Fire Marshal Division

**Re: CHH – Pharmacy Renovation
215 Brightwater Drive
Lillington, NC 27546**

Application Number BCOM1809-0003

1 PARTIAL FIRST FLOOR PLAN - FIRE PROTECTION  
1/4" = 1'-0"

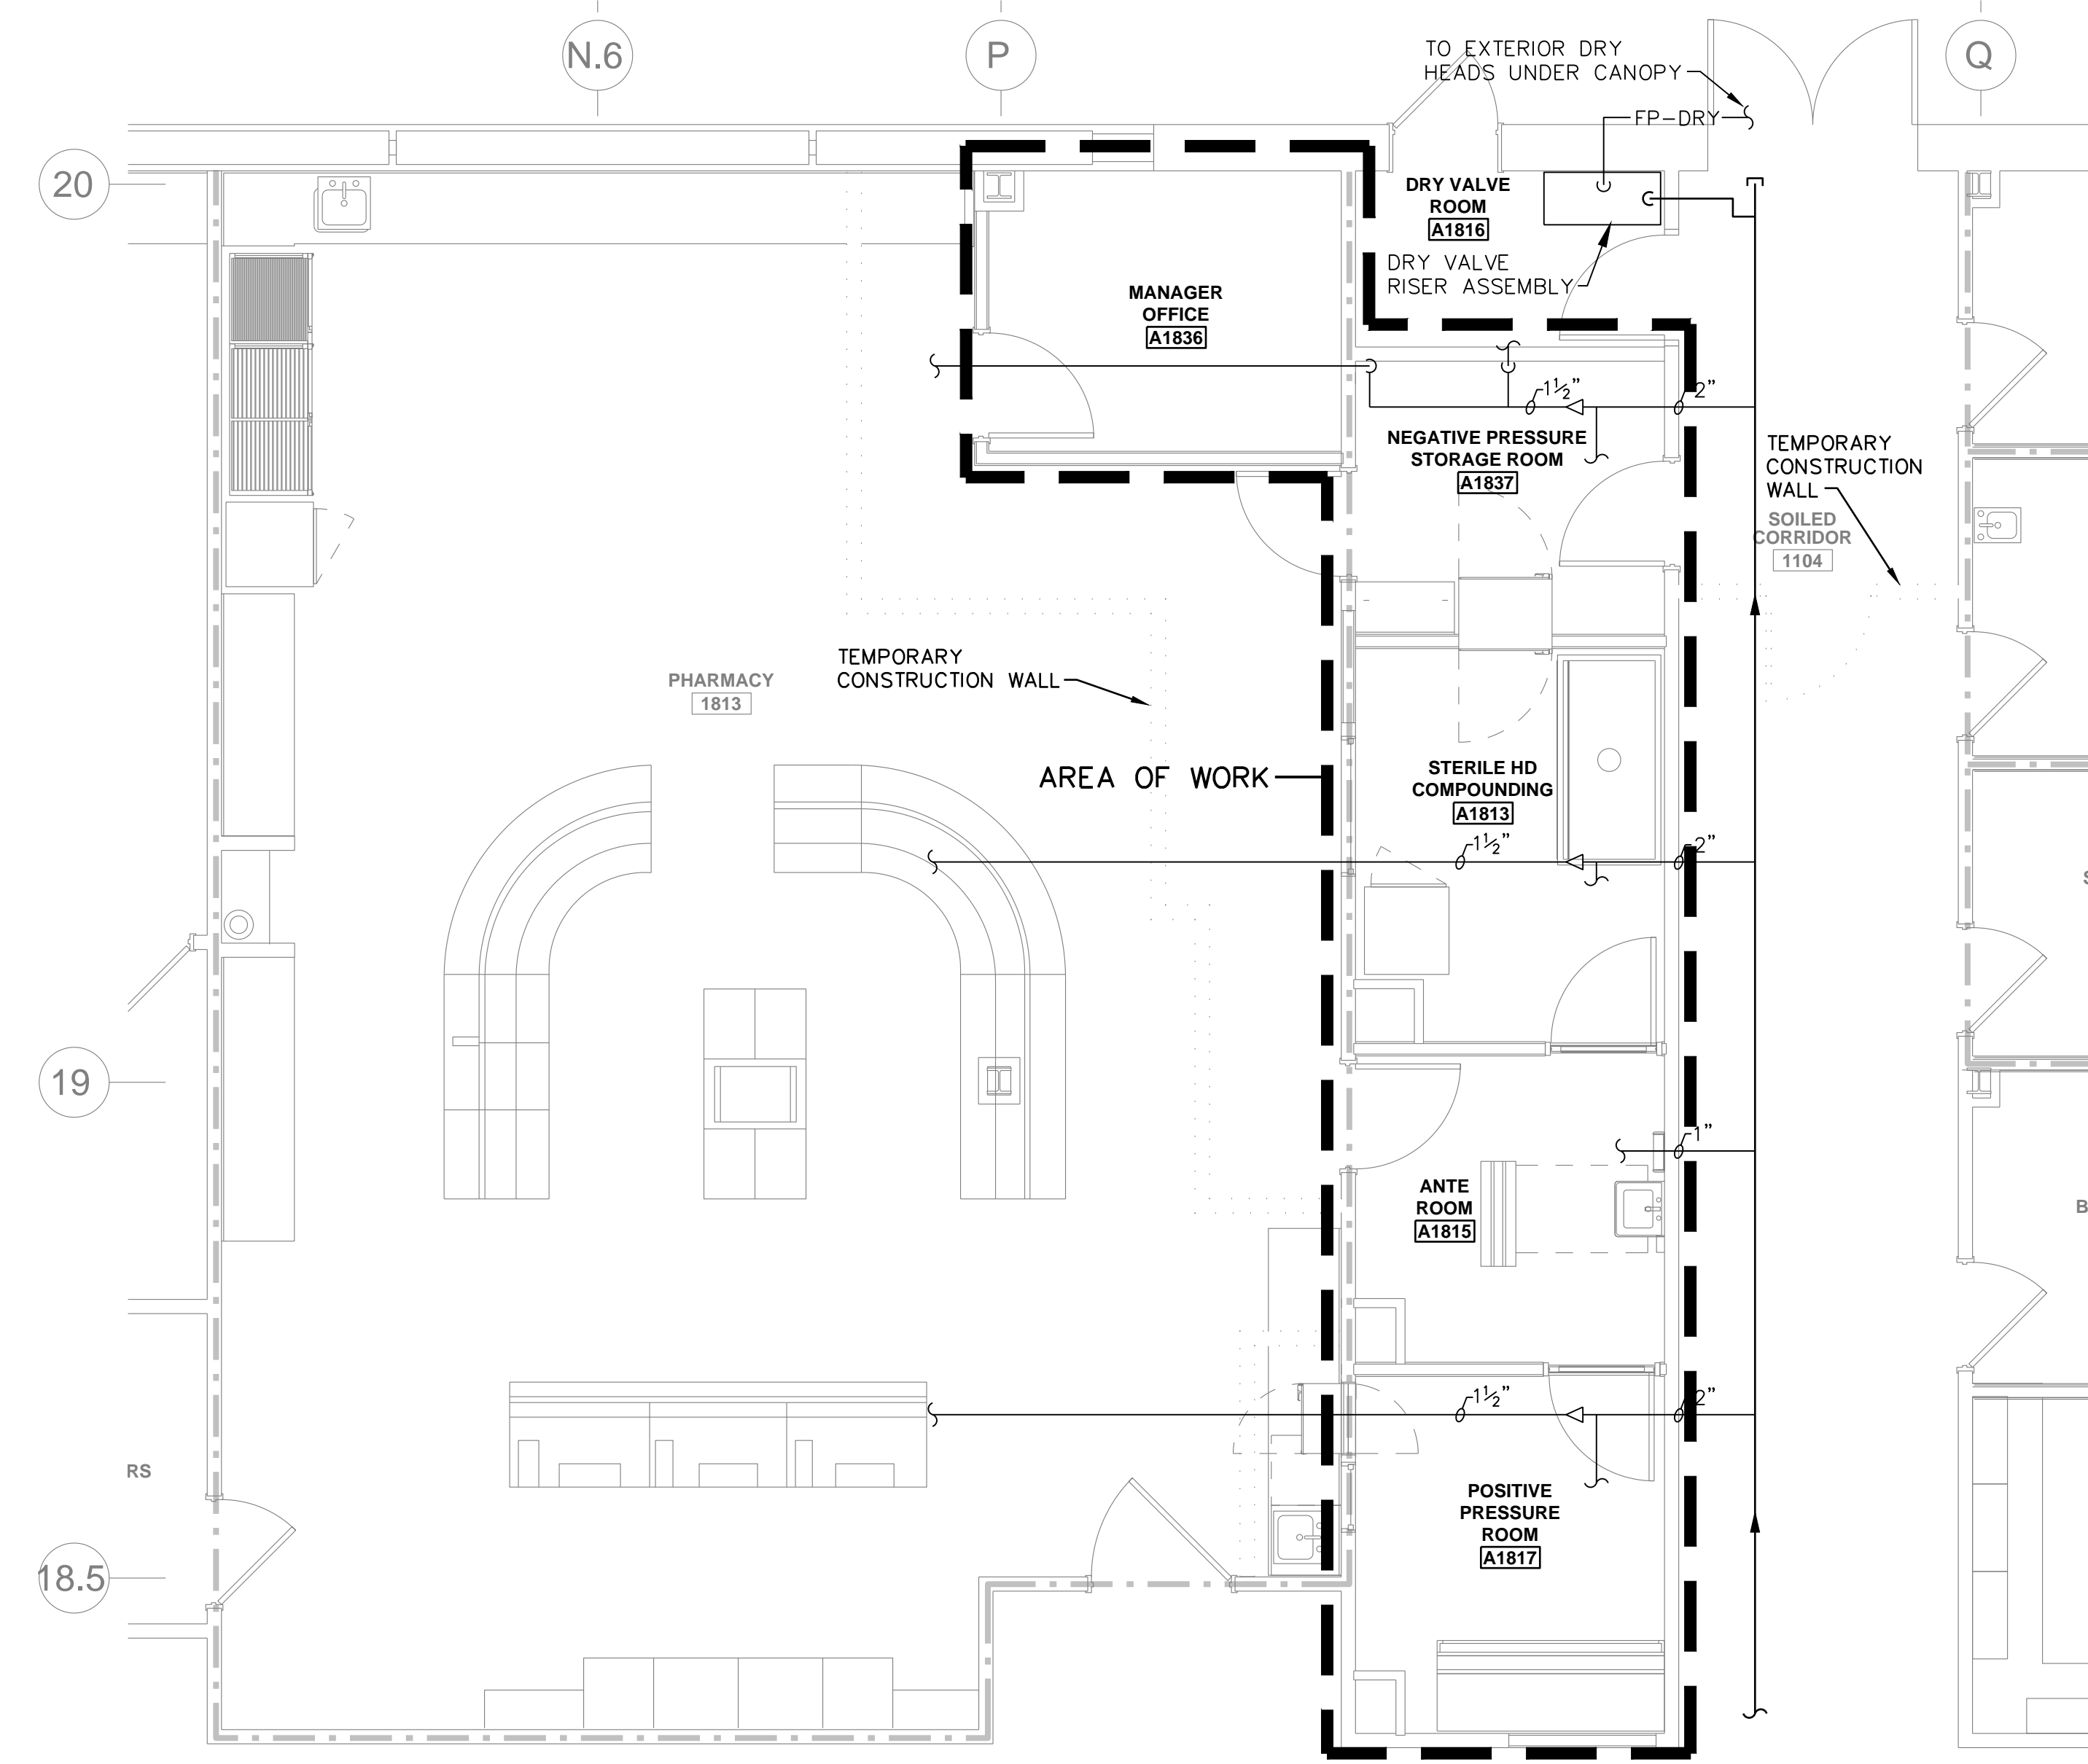
- **Plan Review Comments to Contractor.**
 - Installation of the sprinkler system shall be per contract specifications and NFPA 2013 edition.
 - Provide an FDC detail on the plans, also, the type and size indicated.
 - Provide hydraulic design data plate, spare sprinklers and wrench cabinet, and approved signage at final inspection per NFPA 13.
